Engineers Comments Regarding Surface Water Drainage

Application Reference:	Y/48/25/PL	Reviewer Reference:	ADC/KW and SB
Planning Officer:	Harry Chalk	Date of Review:	11/11/2025
Site Name:	Church Farm House Church Road Yapton BN18 0EP		
Application Description:	Removal of tennis court and construction of 1 No. self-build single storey energy efficient dwelling. This application is a Departure from the Development Plan, may affect the setting of listed buildings, affects the character and appearance of the Church Lane, Yapton Conservation Area and is in CIL Zone 3 and is CIL Liable as a new dwelling.		
Assessment Number:	2 of 2

Appendix A – Soakaway Test Location Plan

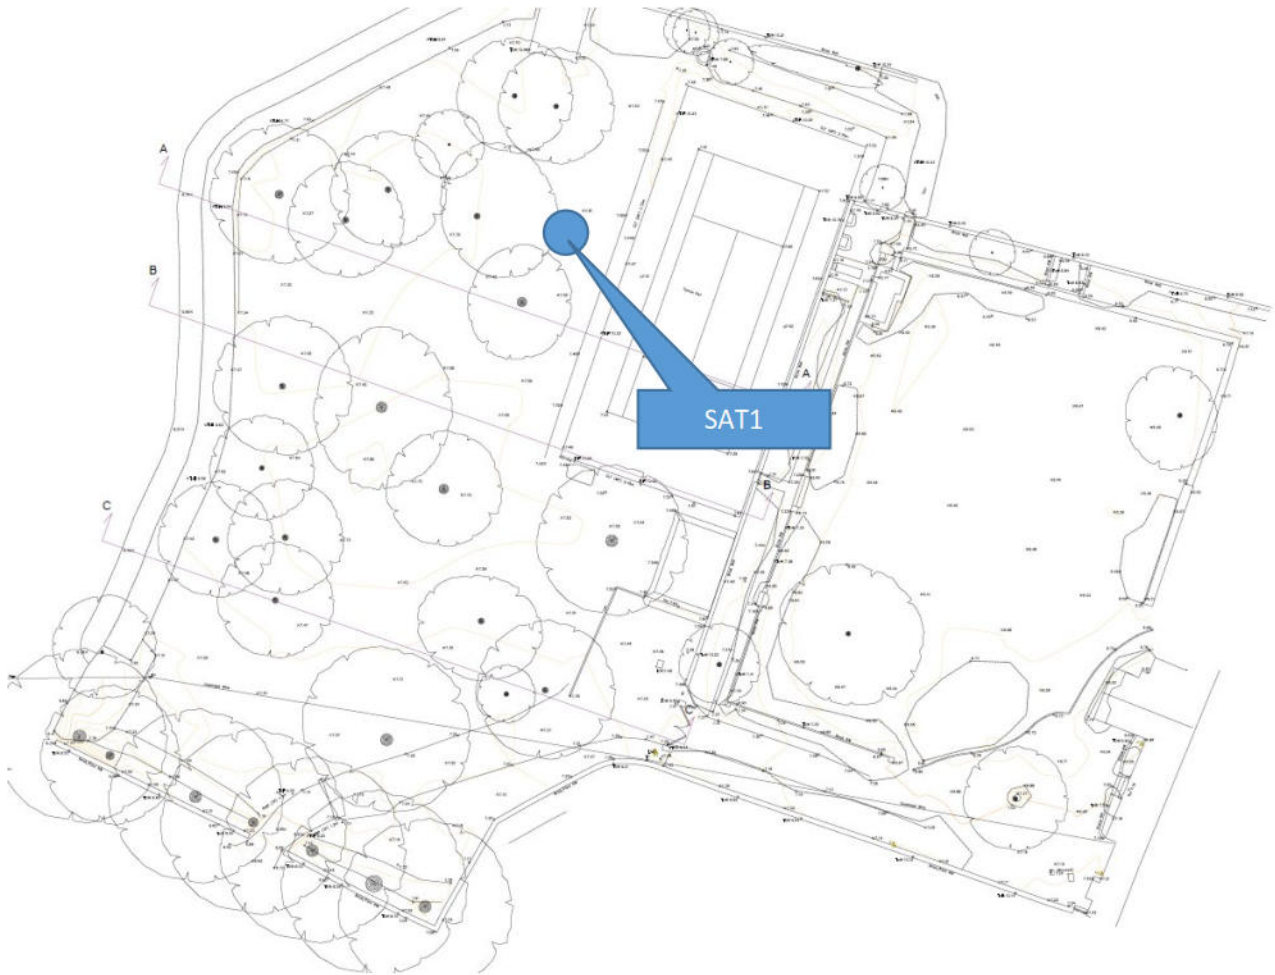
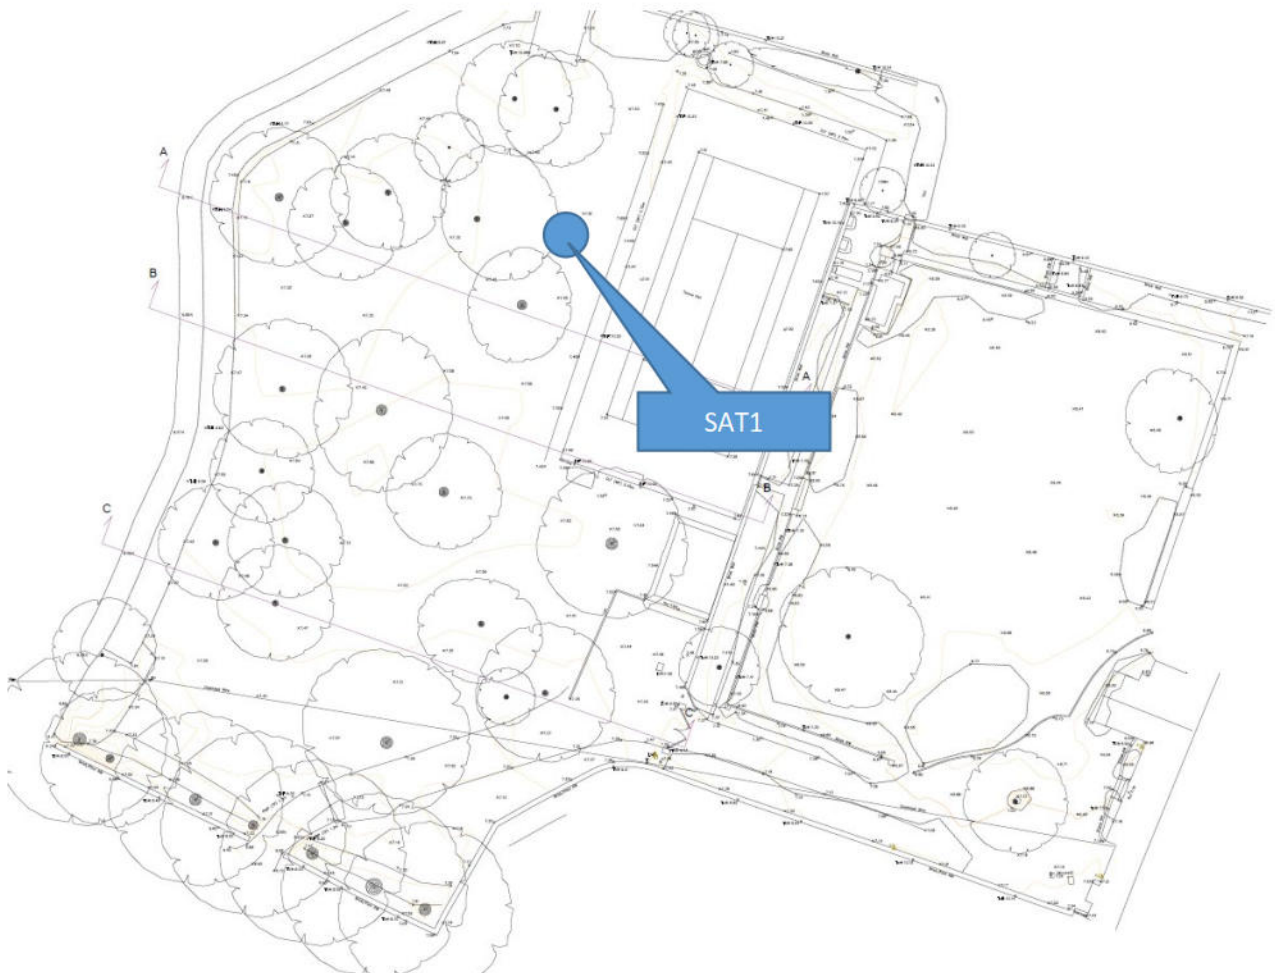
- 1.6. No further infiltration testing has been undertaken. Instead, the updated plans indicate that additional winter testing is required. The Consultants have confirmed that, should a slower infiltration rate be calculated, there is space within the bioretention planters and the rainwater harvesting tank to provide additional storage allowance.

- 1.7. Although there is a level of comfort regarding infiltration, the infiltration rate remains unknown. Despite the ability to provide additional storage within the bioretention planter, it cannot be guaranteed that this will be sufficient, nor can it be guaranteed that the rainwater harvesting tank will

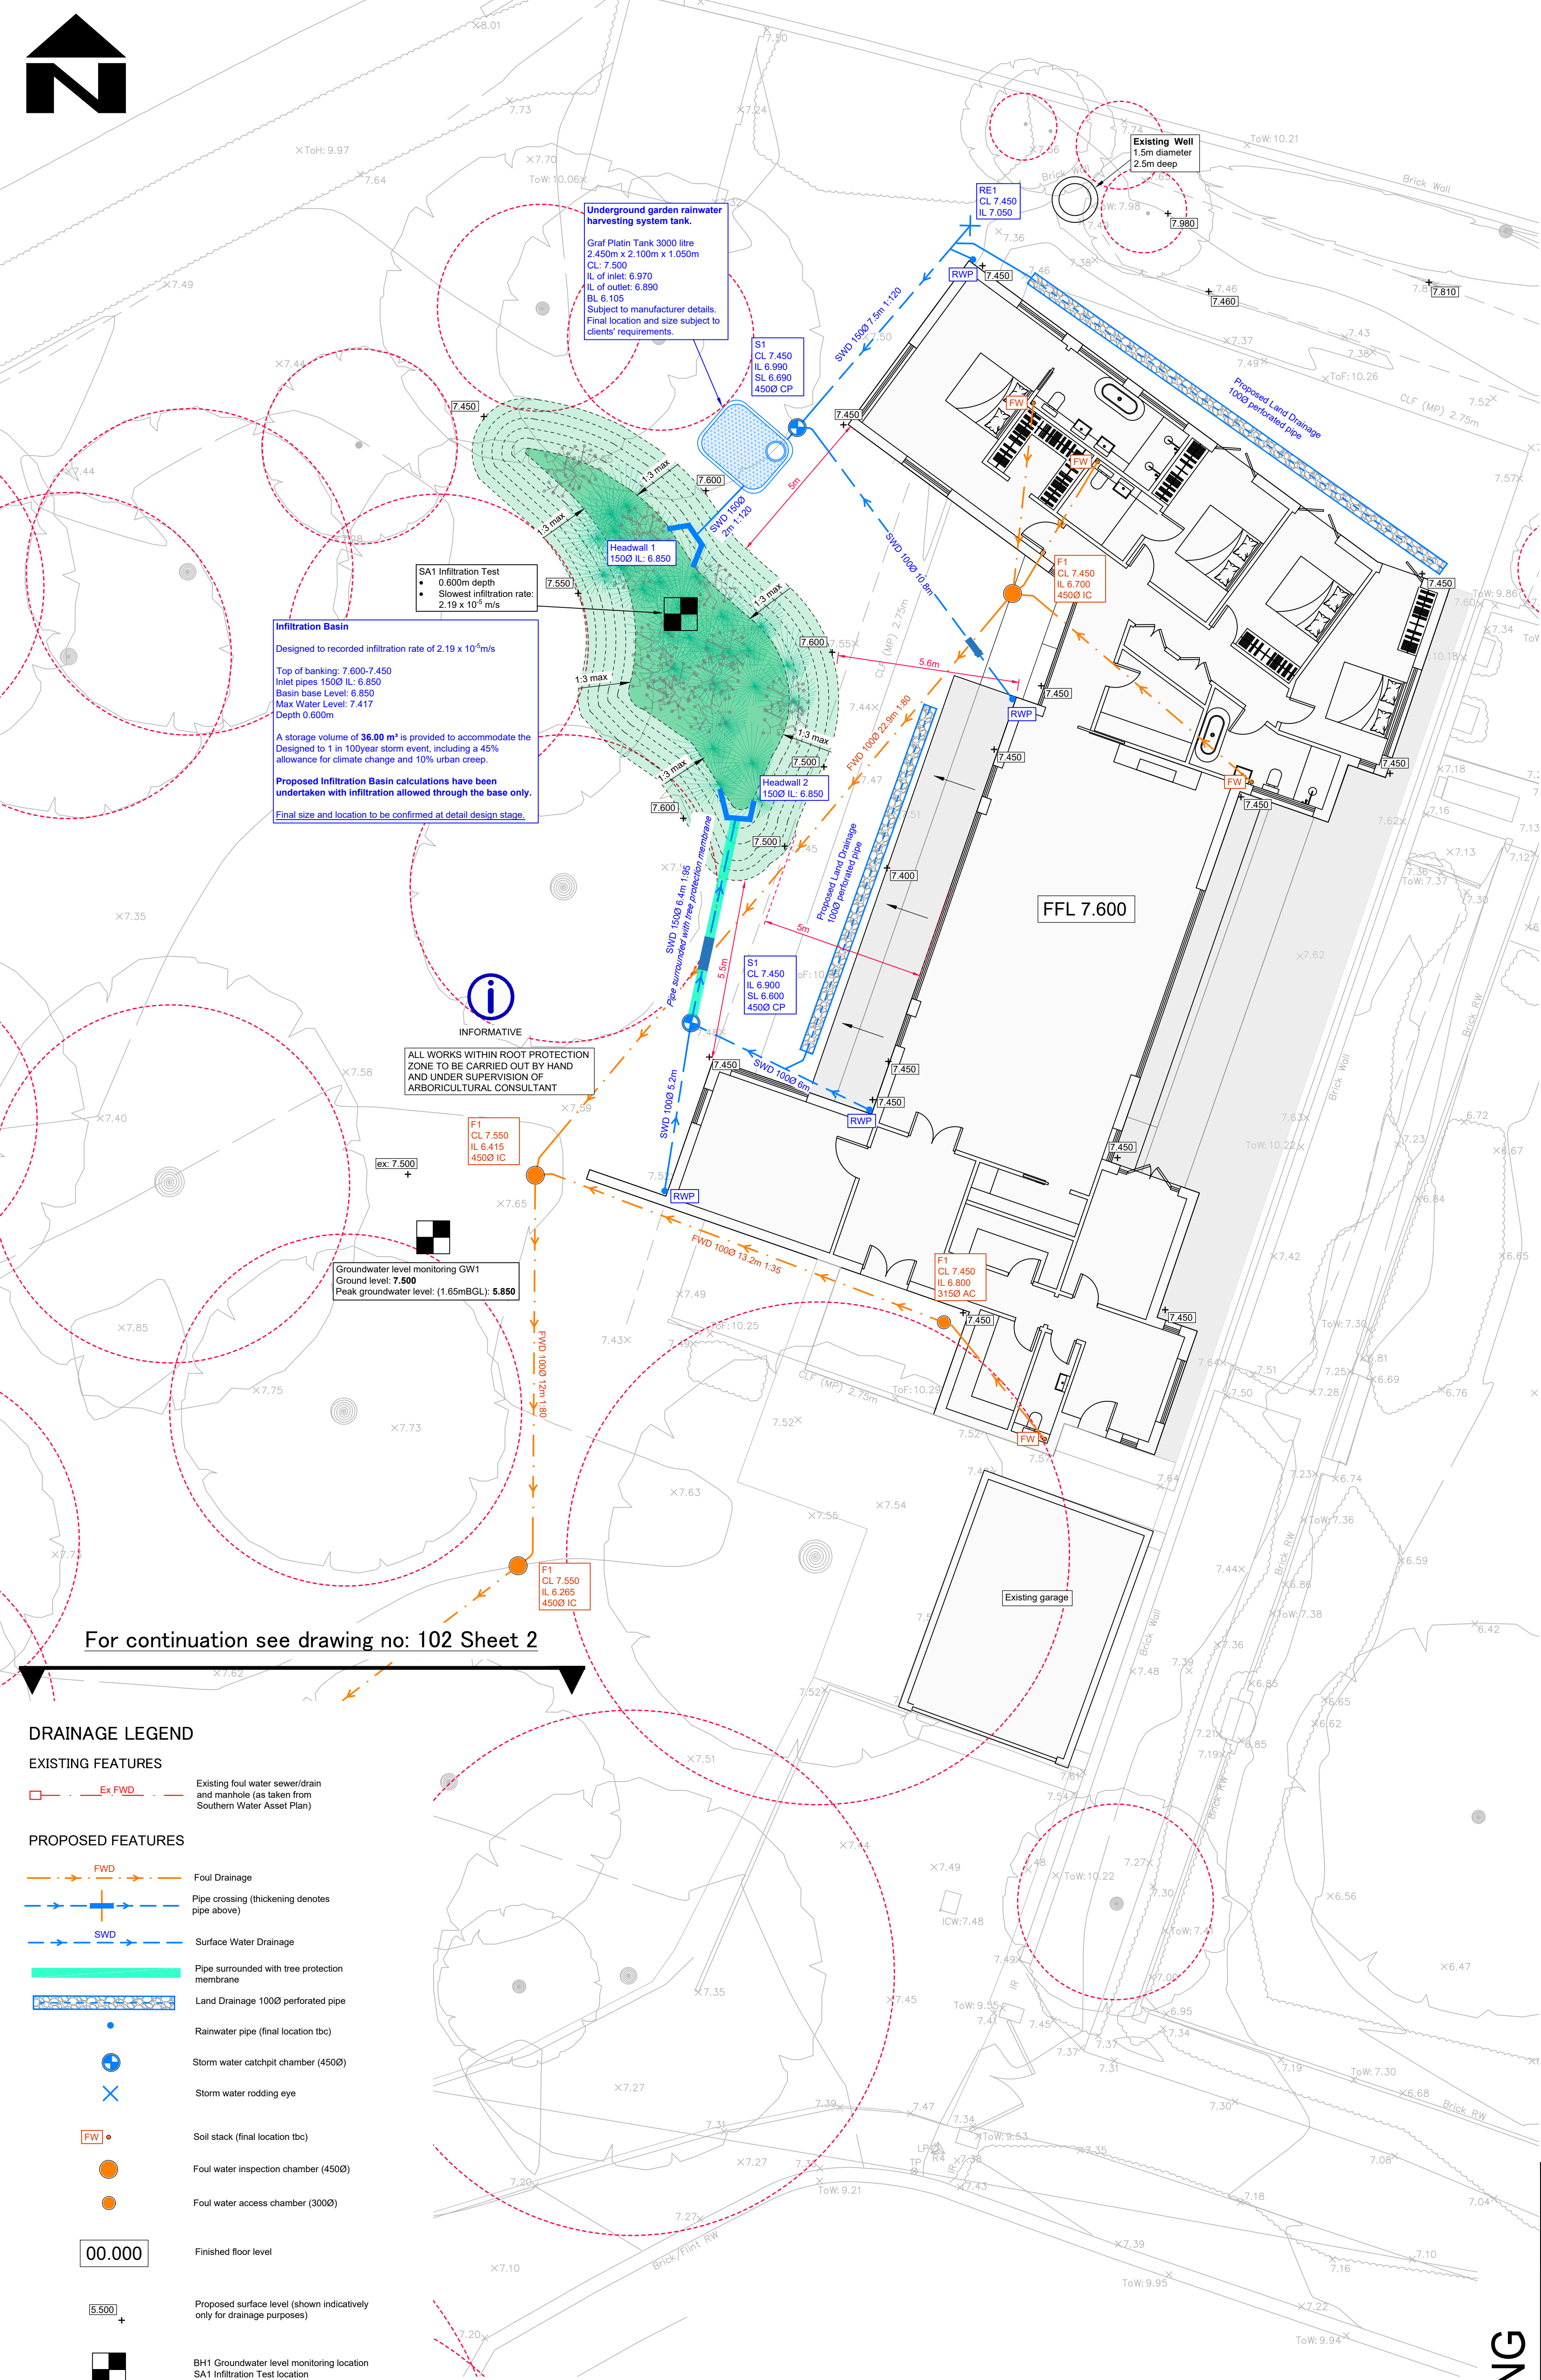
have capacity at the times required (as the heaviest rainfall is likely to occur when the demand for non-potable water is at its lowest). Given this level of uncertainty, and the limited availability of space on site to accommodate the SuDS basin, it would not be appropriate to fix the scale and layout of the development at this stage.

- 3.1. The FSWDR includes drainage plans and modelling. The simulation for the 1% AEP + 45% event has a maximum water level in the basin of 7.439mAOD. The bank at the northeast extent of the infiltration basin has now been increased in height to 7.500 AOD. As a result of the finished floor level of the dwelling being raised to 7.750 AOD, the cover level and rodding eye have also been increased to 7.600 AOD which is acceptable and an appropriate freeboard is now confirmed. Subject to confirmation of an infiltration rate/storage requirements it is now confirmed that the system would not flood during such an event.
- 3.2. It is considered that the proposed design will not negatively impact on the surrounding water environment, and it **is appropriate to lift our objection to Standard 3** subject to securing a detailed design by condition.
